Department of Planning & Infrastructure

Cobbora Coal Project

Review of Surface Water Issues

October 2013

Final Landform Cross-sections

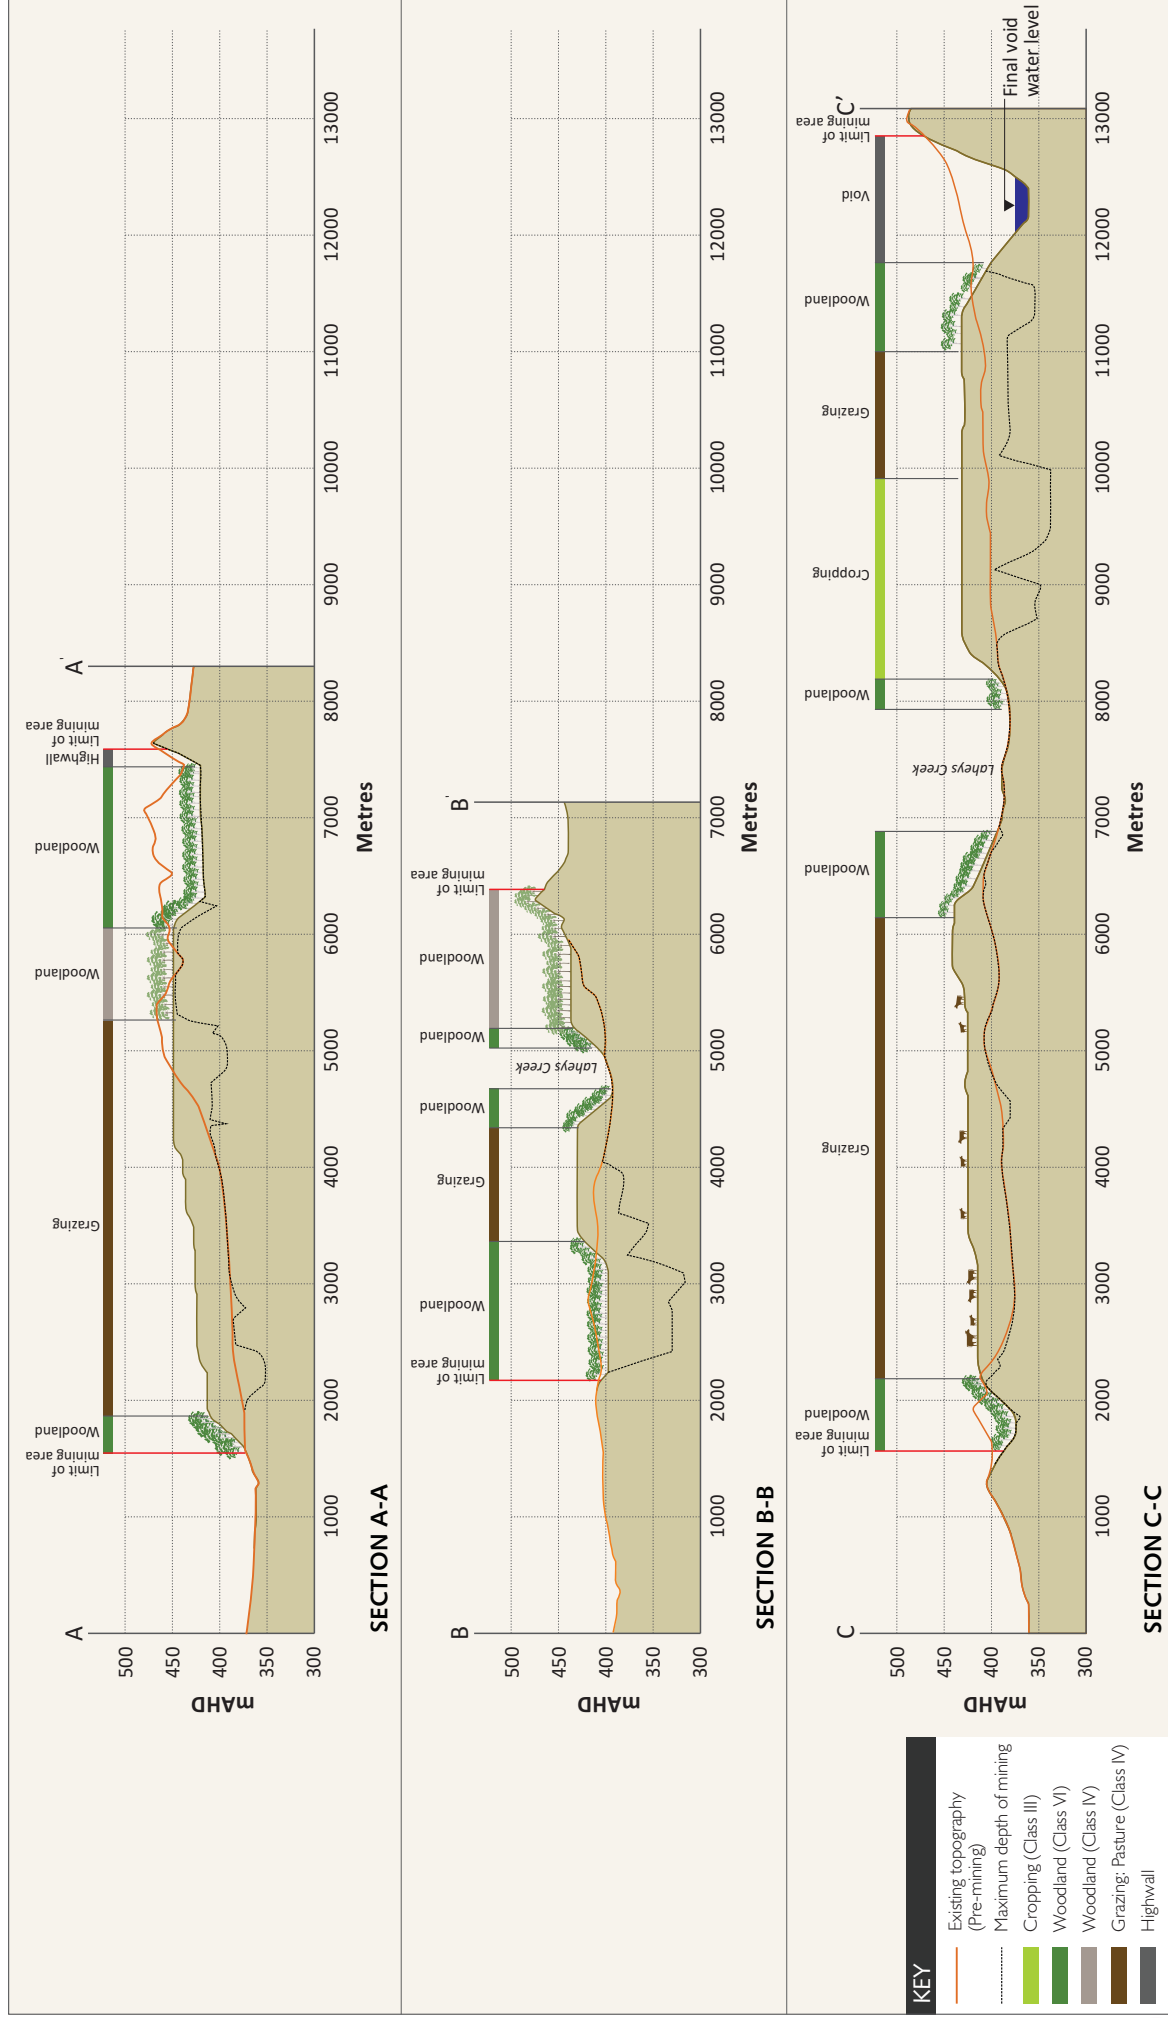
The *PPR* and *Revised PPR* provide no contour details for the final landform and do not indicate the layout of the associated surface drainage systems and their connection with the natural existing creeks.

In order to ensure that drainage is adequately considered the Site Water Management Plan should provide concept design details of the location of all surface drainage lines, including location, indicative cross sections, design flows, design velocities and any proposed scour protection.

Apart from cross sections provided in Figure 3.13 in the *Revised PPR*, no elevation details are provided in any of the mine plans. It is therefore not possible to assess the overall impact of the revised mine plan on the surrounding environment, particularly the interactions between any drainage lines and catchments to be constructed within the final landform and the existing drainage systems. This issue is reviewed further in **Section 2.11**.
